LSC Responses to TIS Redline Comments

Monument Ridge East Traffic Impact Study (LSC #S234450) March 11, 2024

Add PCD File No. P245

Figure 3  
Proposed Realignment  
of Monument Hill Rd  
and Extension of  
Misty Acres Blvd

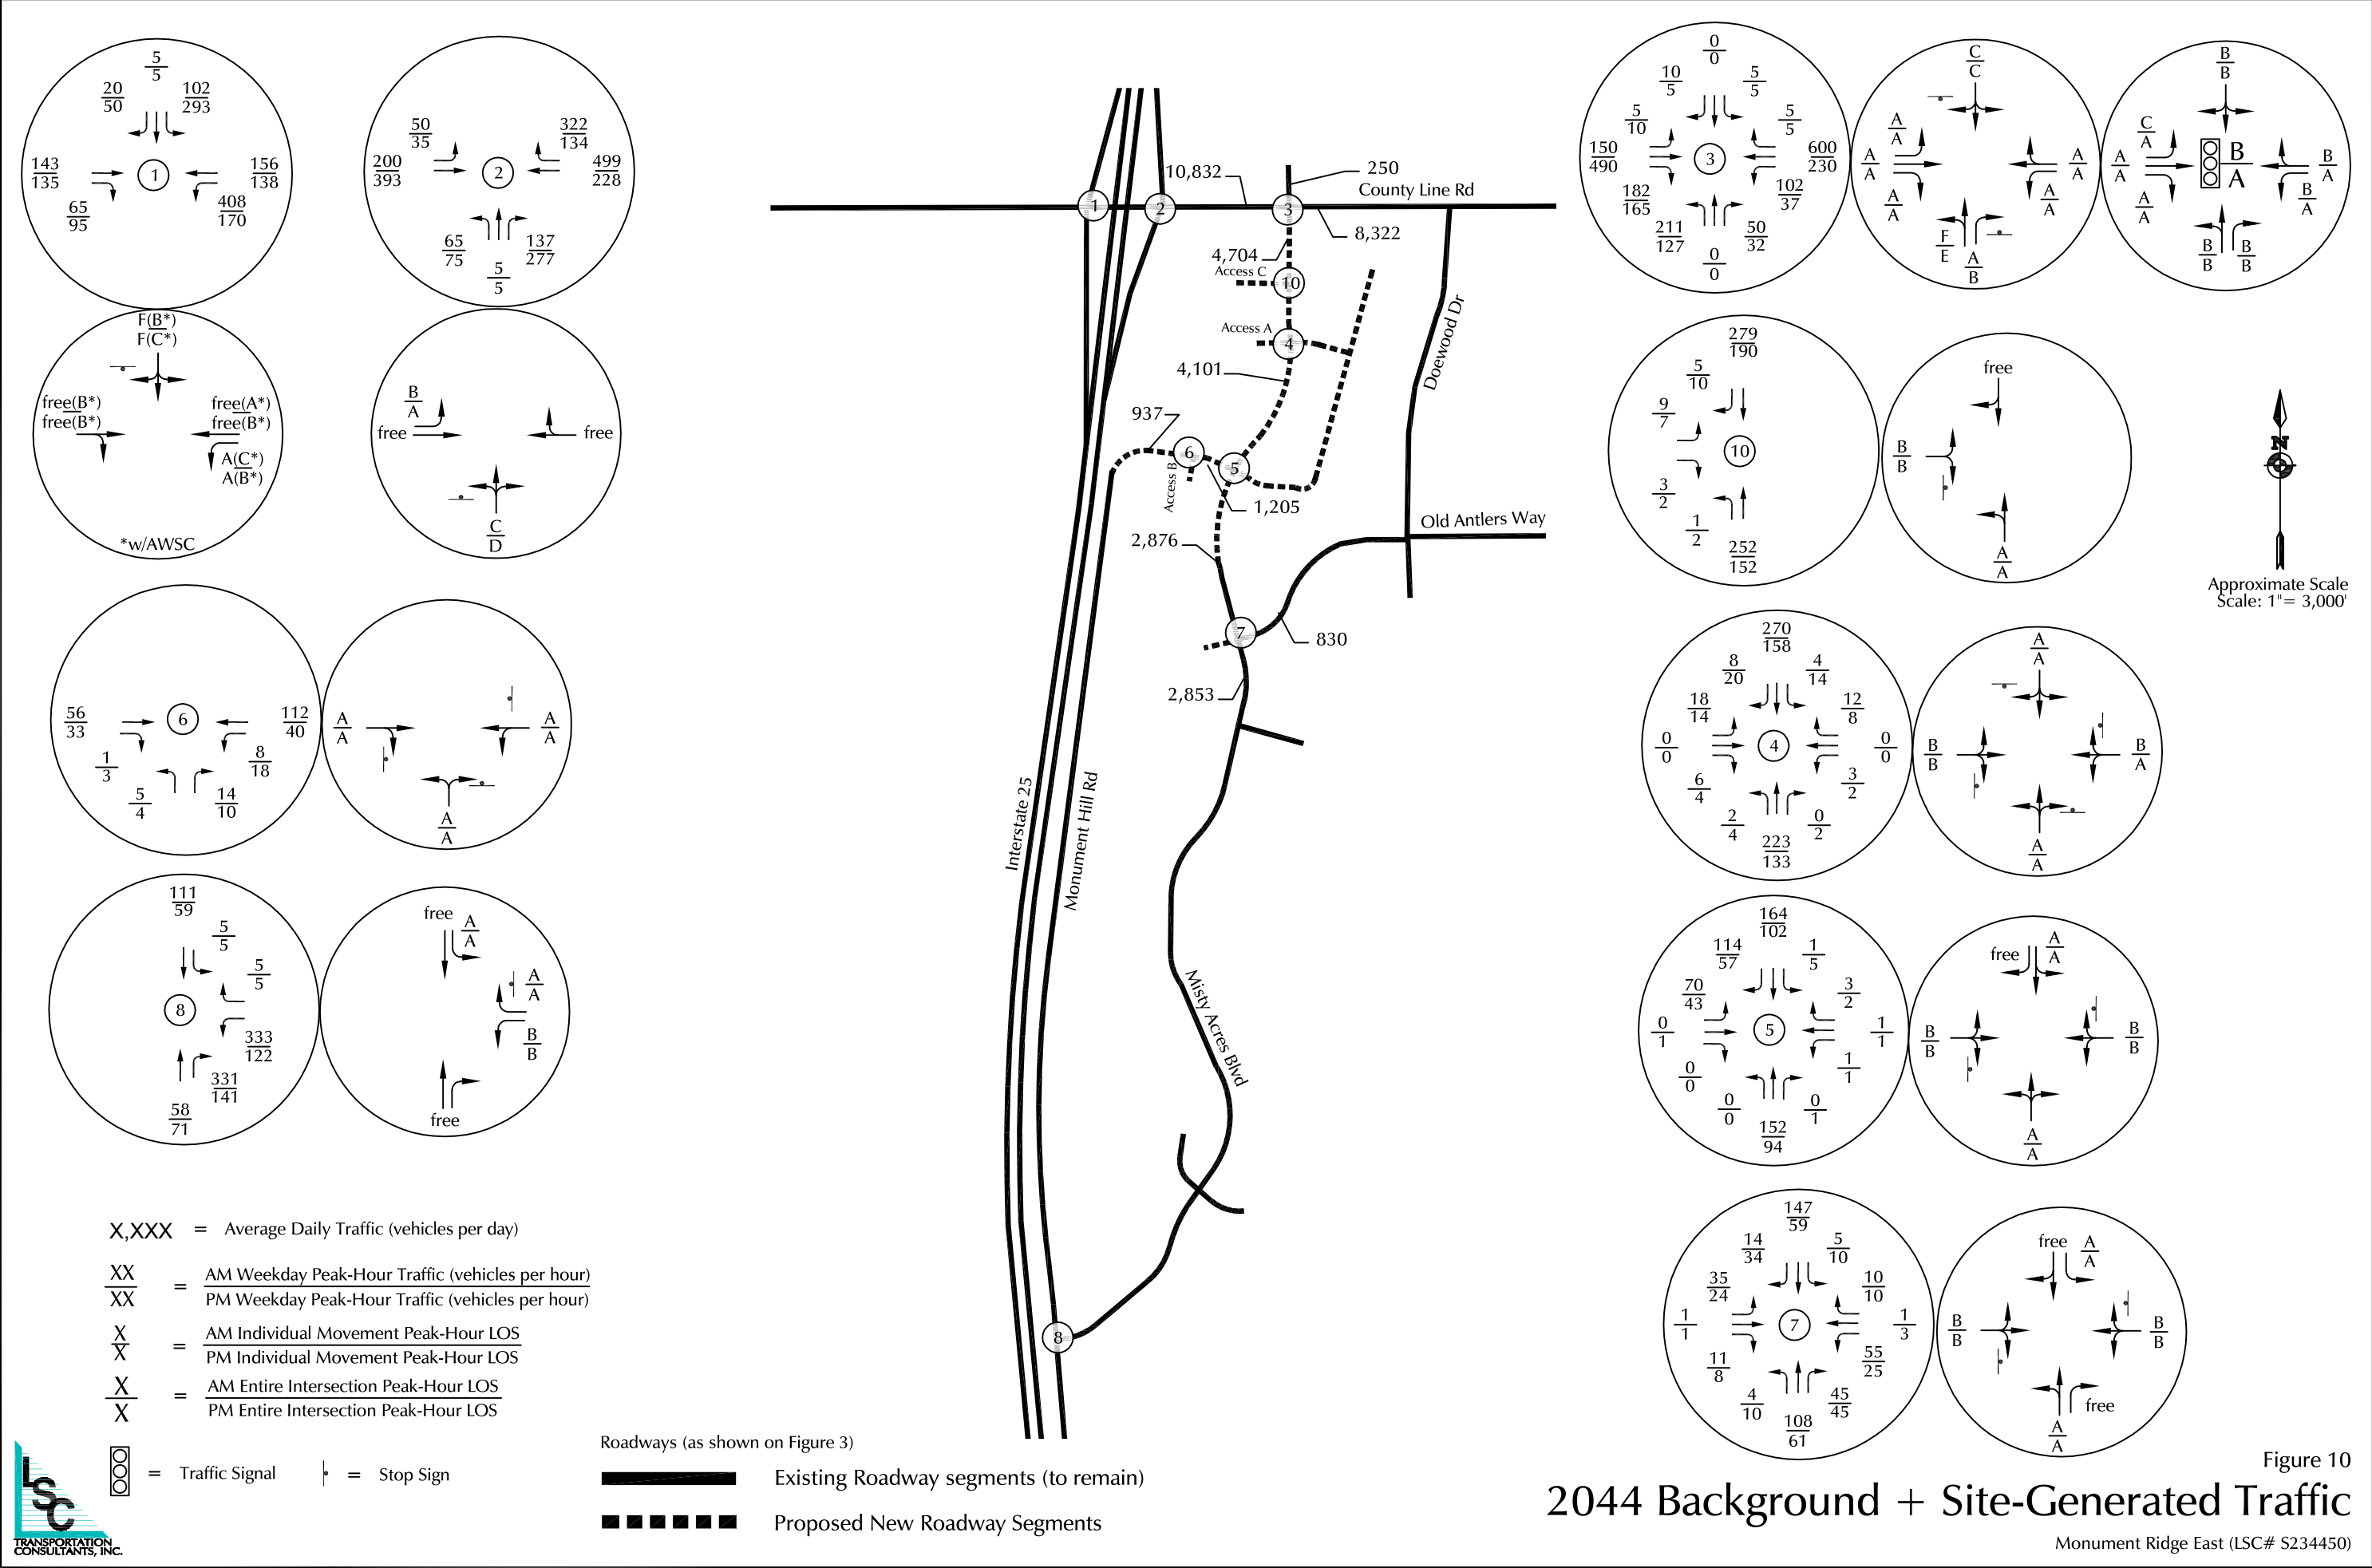
It appears that Monument Hill Road classified as a rural major collector. Please revise.

Author: Jeff Date: 8/7/2024 1:50:49 PM
LSC RESPONSE: Revised as requested.
